DECISION NOTICE

Application Ref: BR/233/19/PL

77 Aldwick Road
Bognor Regis
PO21 2NW

Part change of use of ground floor & formation of a first floor rear extension to create 2 No self-contained studio flats with associated refuse/ recycling & cycle store (resubmission following BR/63/18/PL).

Drawing
EXISTING & PROPOSED
ELEVATIONS

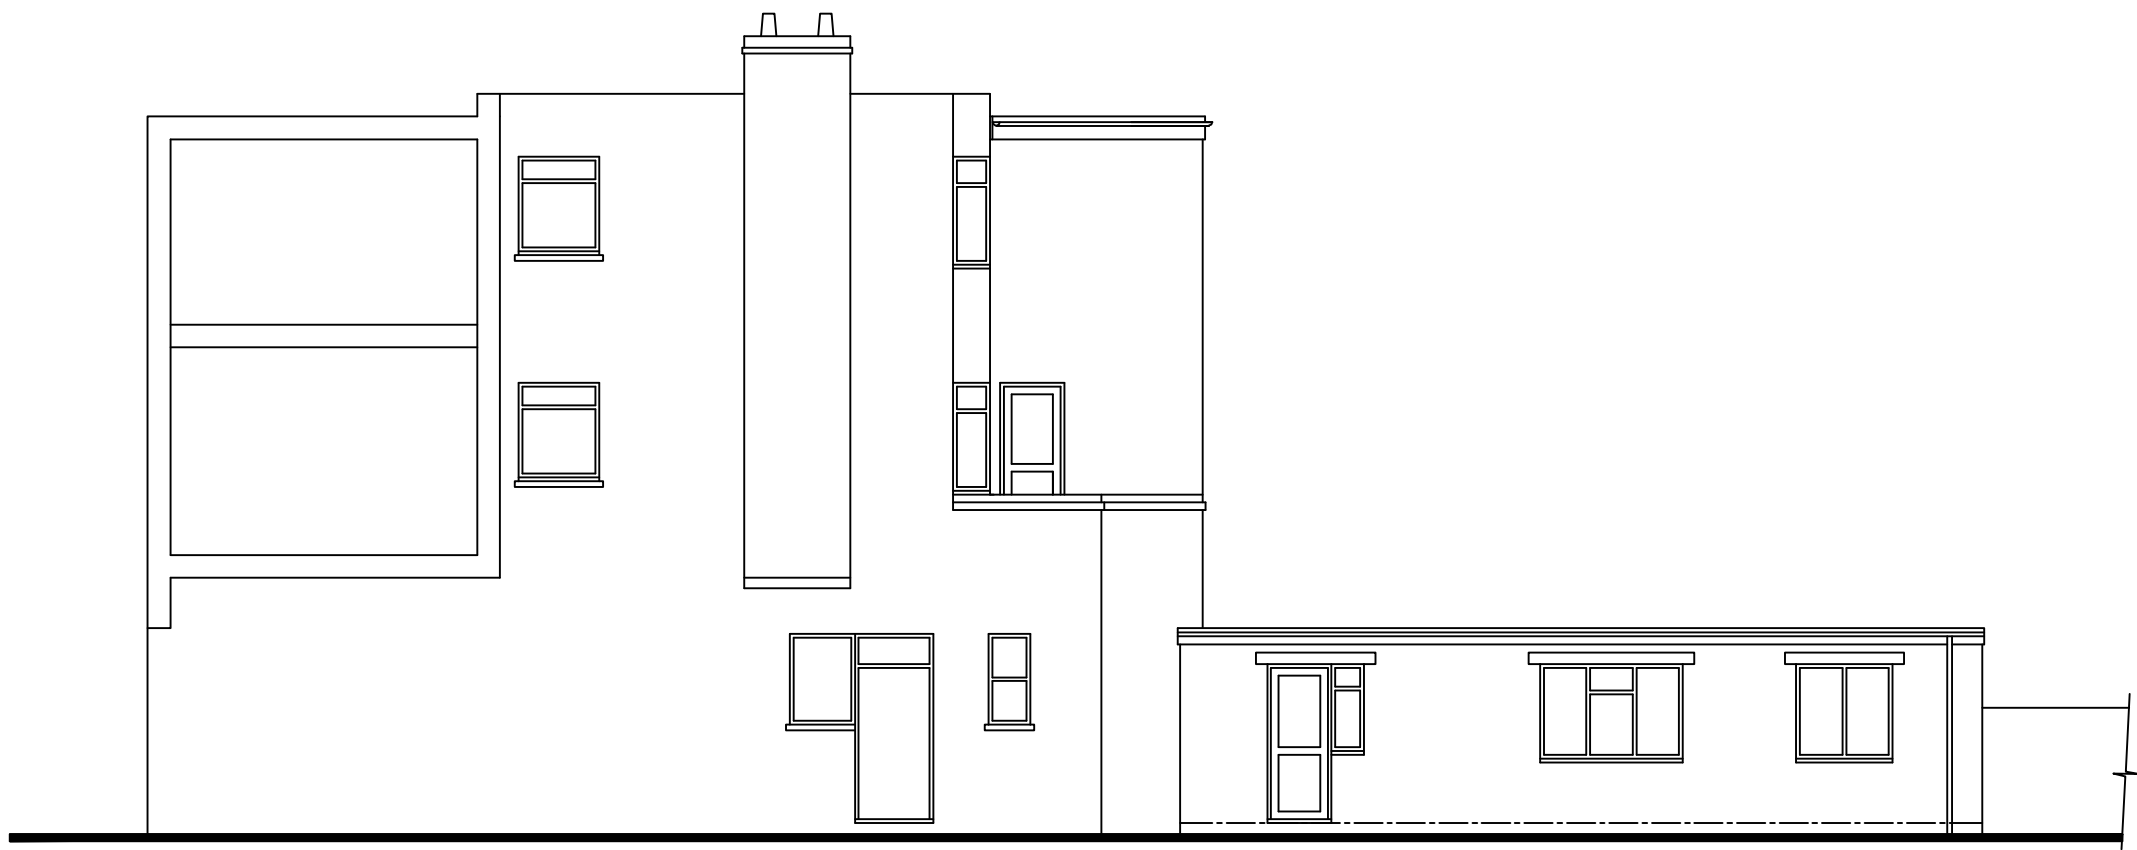
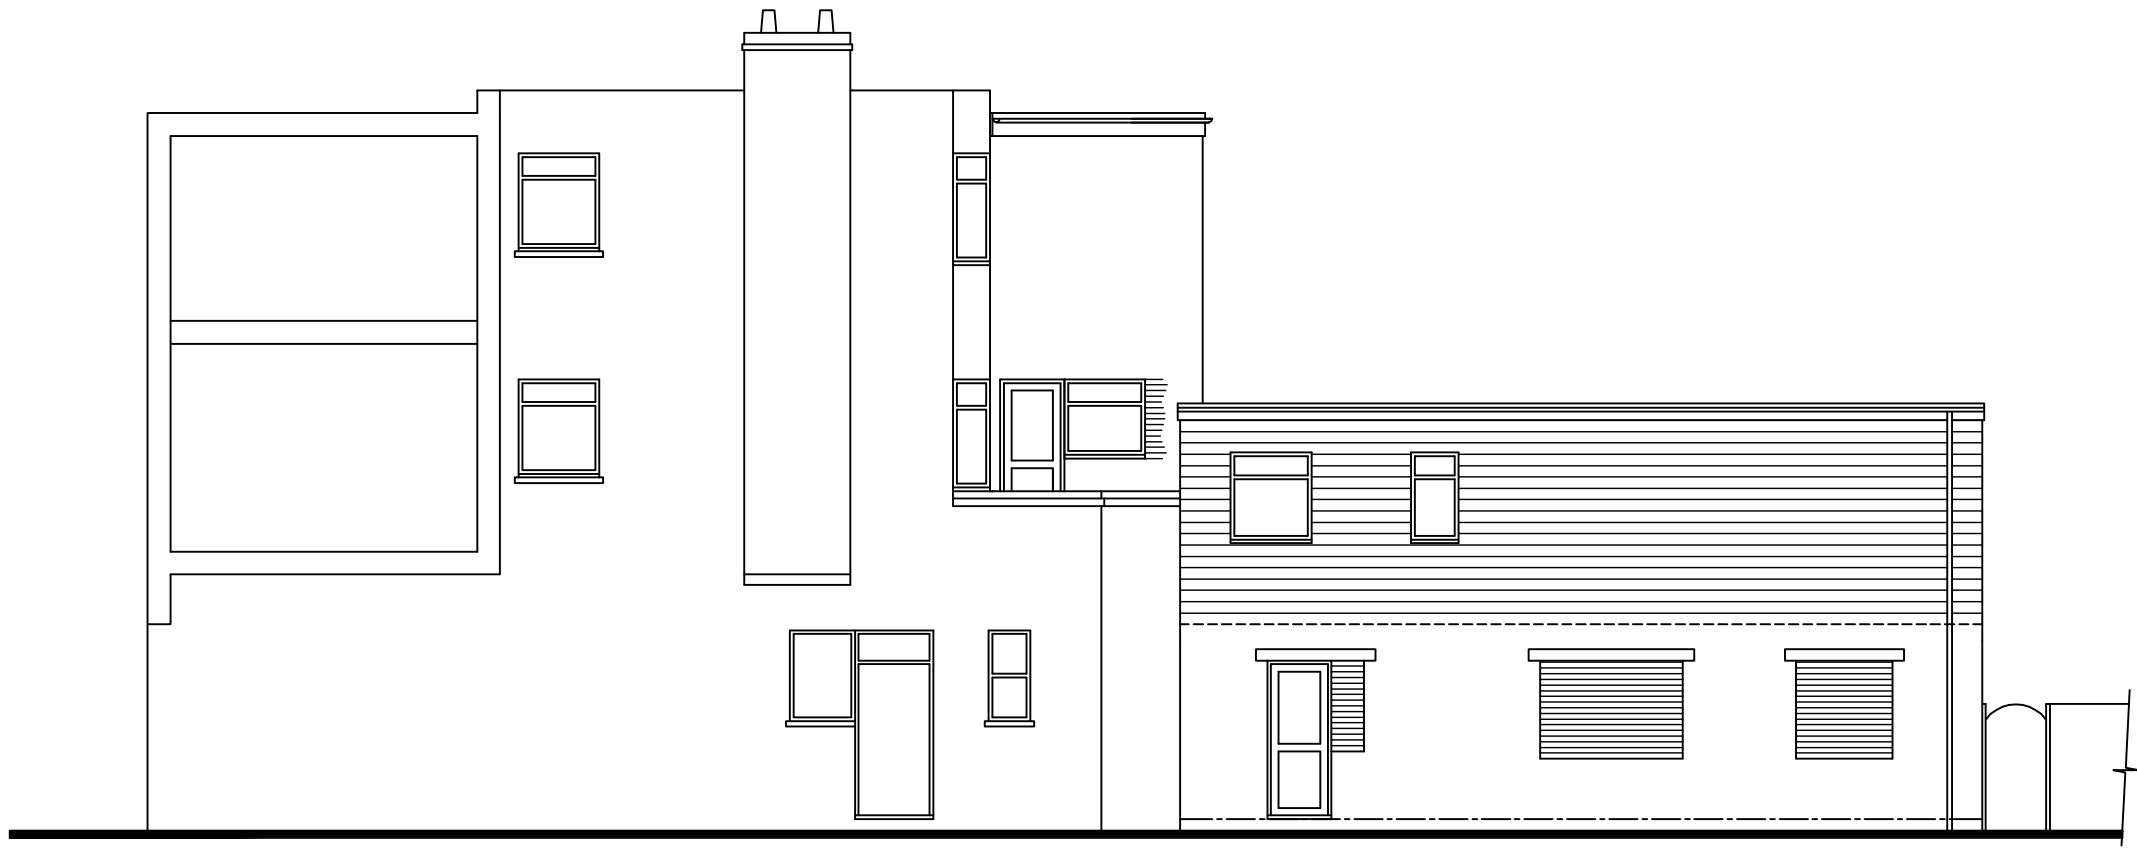
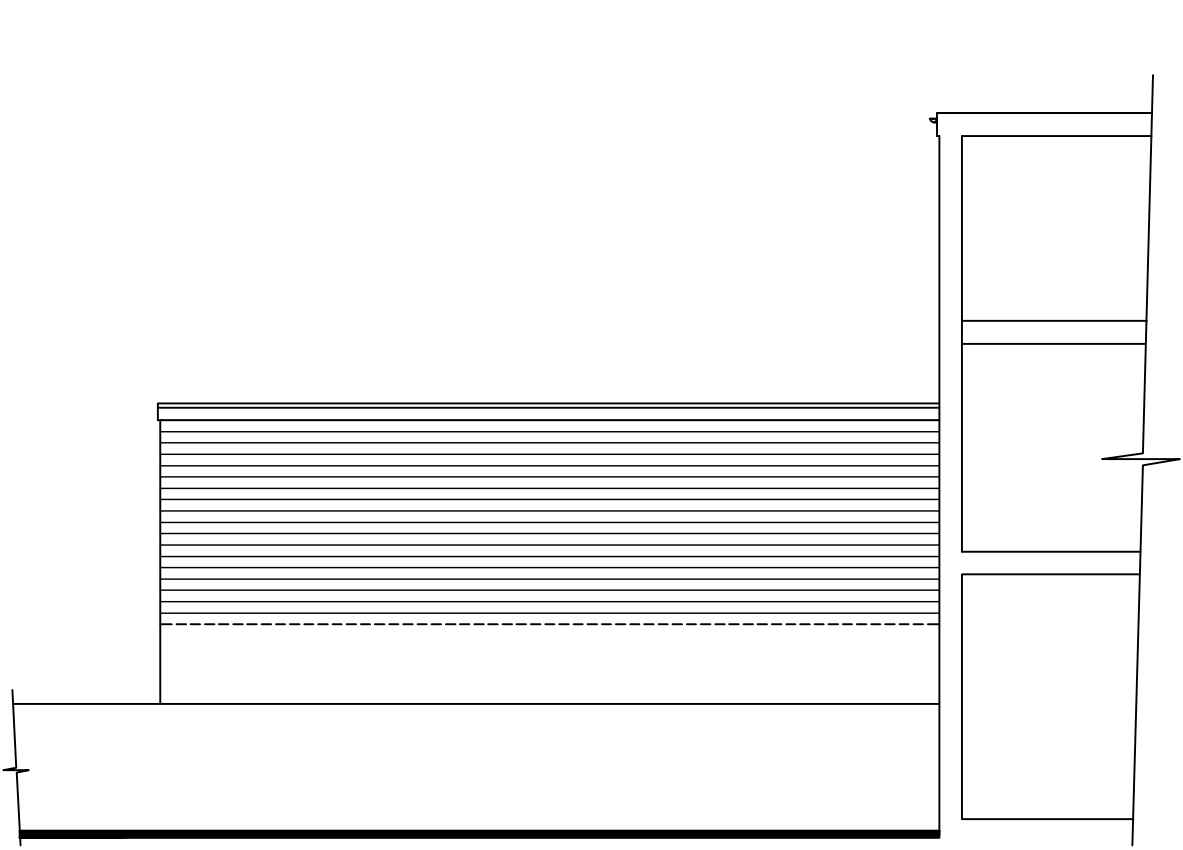
- 1 The height and scale of the proposed additional first floor extension to the rear of 77 Aldwick Road will result in an overbearing impact on, and loss of outlook to, the amenity of the existing windows of the first floor residential flats in the rear of 75 - 79 Aldwick Road. In the absence of a full BRE sunlight/daylight study there Local Planning Authority has not been satisfied that there will not be a demonstrable harmful loss of sunlight/daylight to neighbouring residential properties. The proposal is therefore contrary to policies D SP1, D DM1, D DM2 and QE SP1 of the Arun Local Plan and the National Planning Policy Framework.

- 2 The new first floor studio apartment window on the southern elevation of the building will look out towards the rear private amenity spaces of nos. 10 and 14/16 Stocker Road at a distance of around 8.8m. In the absence of requested sight line sections/diagrams the proposal will result in a loss of privacy to the adjacent amenity spaces of nos. 10 and 14/16 Stocker Close; contrary to Policies D DM1, D DM4 and QE SP1 of the Arun Local Plan and National Planning Policy Framework.
